**Subject:** Fwd: RE: Application No: 2025/44/92737/E - Objection to Planning Application – Development to the Rear of 23–43 Moor Lane

| Drawing Title: Surface Water Management Plan | | | | |

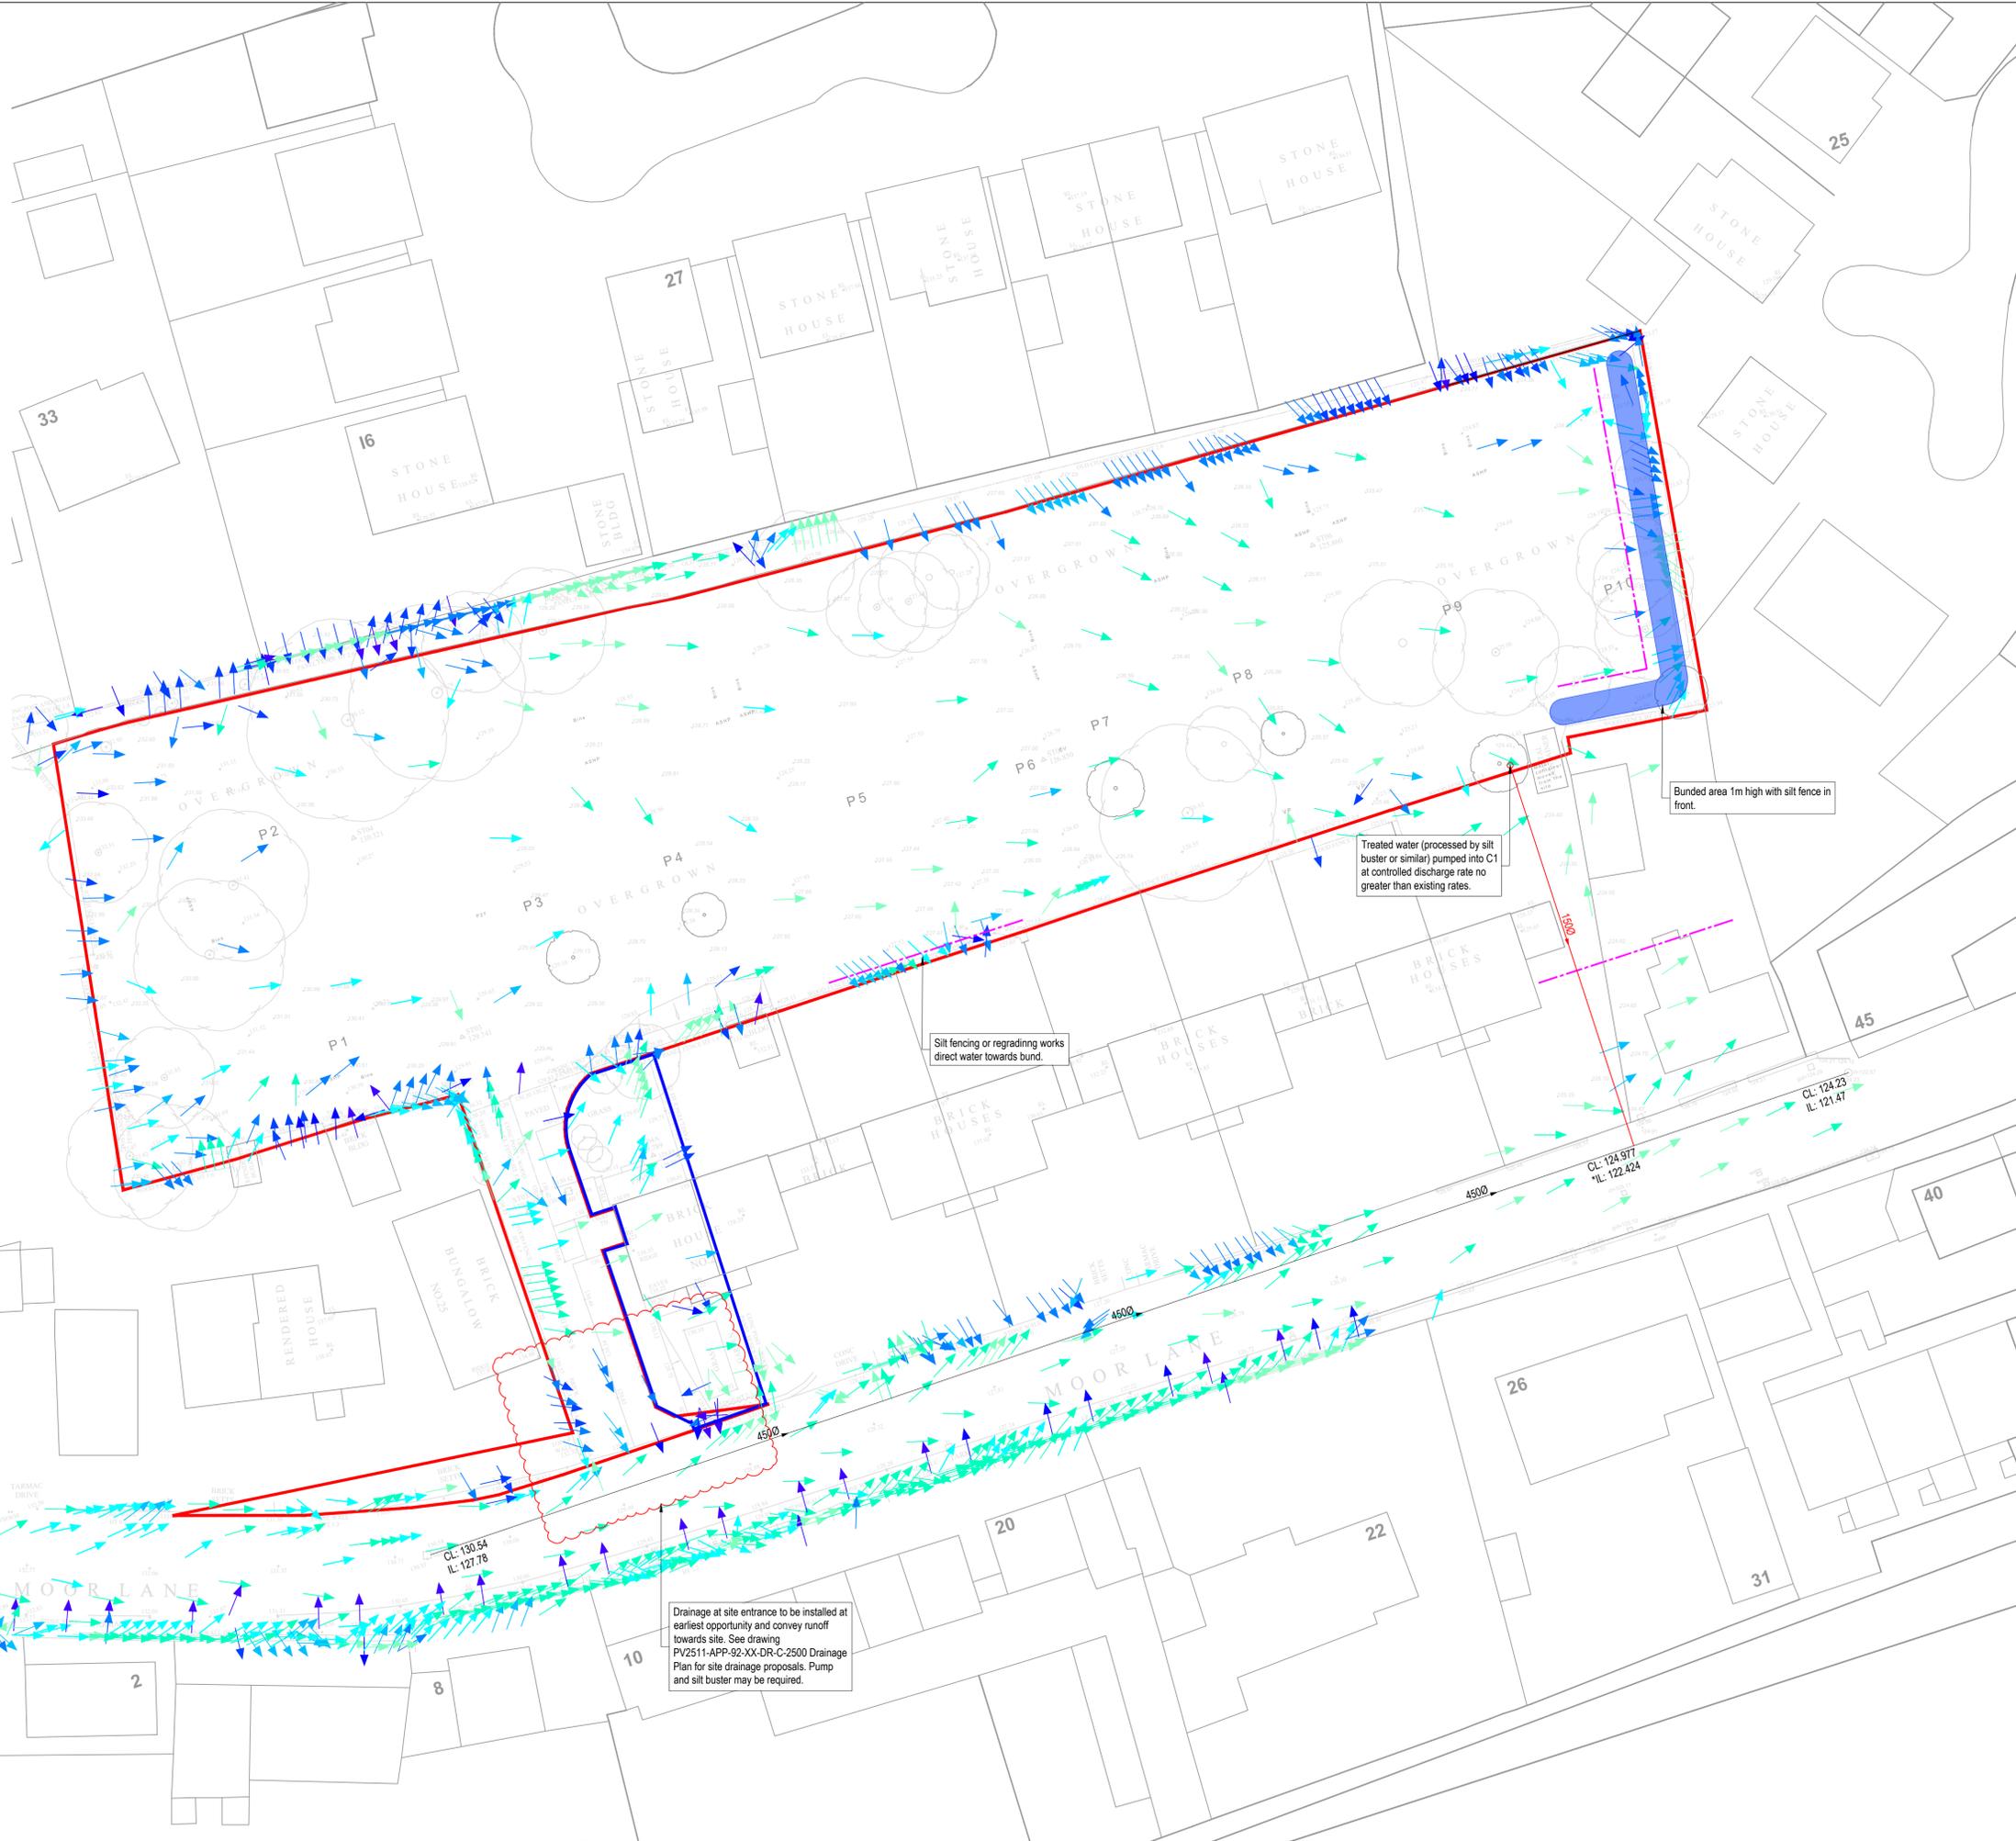
The revised drainage proposals do little to reassure me that the development will not exacerbate these existing problems. Indeed, the inclusion of a silt fence and a one-metre-high bund immediately behind our property appears to acknowledge that flooding and surface water management present a significant challenge on the site. Should these measures prove inadequate, deteriorate over time, or become overwhelmed by increasingly severe weather events, it is neighbouring existing properties such as ours and the adjacent property on Summerdale that would bear the consequences.

I am also extremely concerned about the proposed installation of the 1500mm treated water pipe through the adjoining council-owned land. In the event of any future failure, leakage or maintenance issue, the natural flow path would direct water towards our driveway and garage, creating a further flood risk to our property. Furthermore, as previously raised, the plans appear to indicate that part of this infrastructure may encroach beneath the upper corner of our driveway. We have never been consulted regarding this matter and would strongly object to any such encroachment onto our property.
